KITTTITAS COUNTY COMMUNITY DEVELOPMENT SERVICES

July 29, 2008

RE: Schmaus #2 Short Plat (SP-07-134)

Kittitas County Community Development Services has determined that the Schmaus #2 Short Plat (SP-07-134) is a complete application and hereby grants **conditional preliminary approval** subject to the following conditions:

SCHMAUS #2 SHORT PLAT A PORTION OF THE SOUTHWEST 1/4 OF SECTION 21, TOWNSHIP 20 NORTH, RANGE 14 EAST, W.M., KITTITAS COUNTY, WASHINGTON

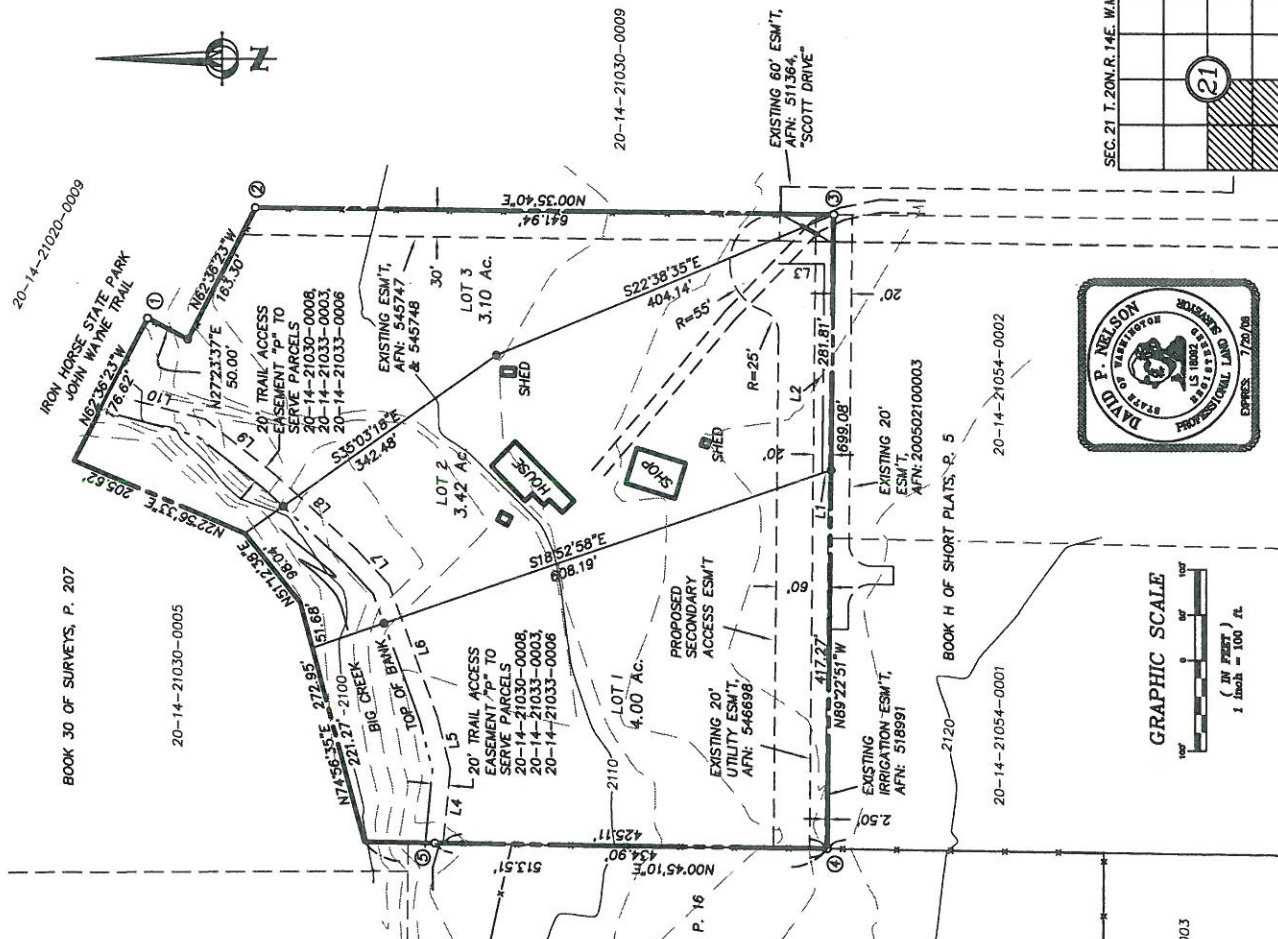
- 1) Both sheets of the final mylars shall reflect short plat number SP-07-134 and an accurate legal description shall be shown on the face of the final plat.
- 2) Current full year's taxes must be paid on all tax parcel numbers per requirement of the Kittitas County Treasurer's Office.
- 3) All development shall comply with the International Fire Code and its Appendices.
- 4) Soil logs must be performed at a mutually convenient time and water availability is needed. Proof of both shall be provided to Community Development Services prior to final approval.
- 5) Portions of the property are located within the shoreline jurisdiction of Big Creek, a designated Shoreline of the State. Big Creek shall be shown on the face of the final mylars and its associated floodplain shall also be depicted.
- 6) A plat note shall be added as follows:

Portions of the Schmaus #2 Short Plat (SP-07-134) are located within the shoreline jurisdiction of Big Creek, a designated Shoreline of the State. There shall be a 100 foot structural setback from the Ordinary High Water Mark (OHWM) of Big Creek and any work to be completed within 200 feet of the OHWM of Big Creek shall require further review and possible permitting by Community Development Services.

- 7) The Schmaus #2 Short Plat (SP-07-134) shall share one daily groundwater exemption of 5,000 gallons per day with the Schmaus #3 Short Plat (SP-07-146) and the Schmaus #4 Preliminary Plat (P-07-55). This 5,000 gallons shall be shared between all 13 lots combined, allowing each lot 385 gallons per day. All wells associated with the three plats shall be metered and records documenting water usage shall be submitted to the Department of Ecology by January 31st of each year.
- 8) The existing well, located on Lot 2, shall be shown on the final mylars.
- 9) A plat note shall be added as follows:
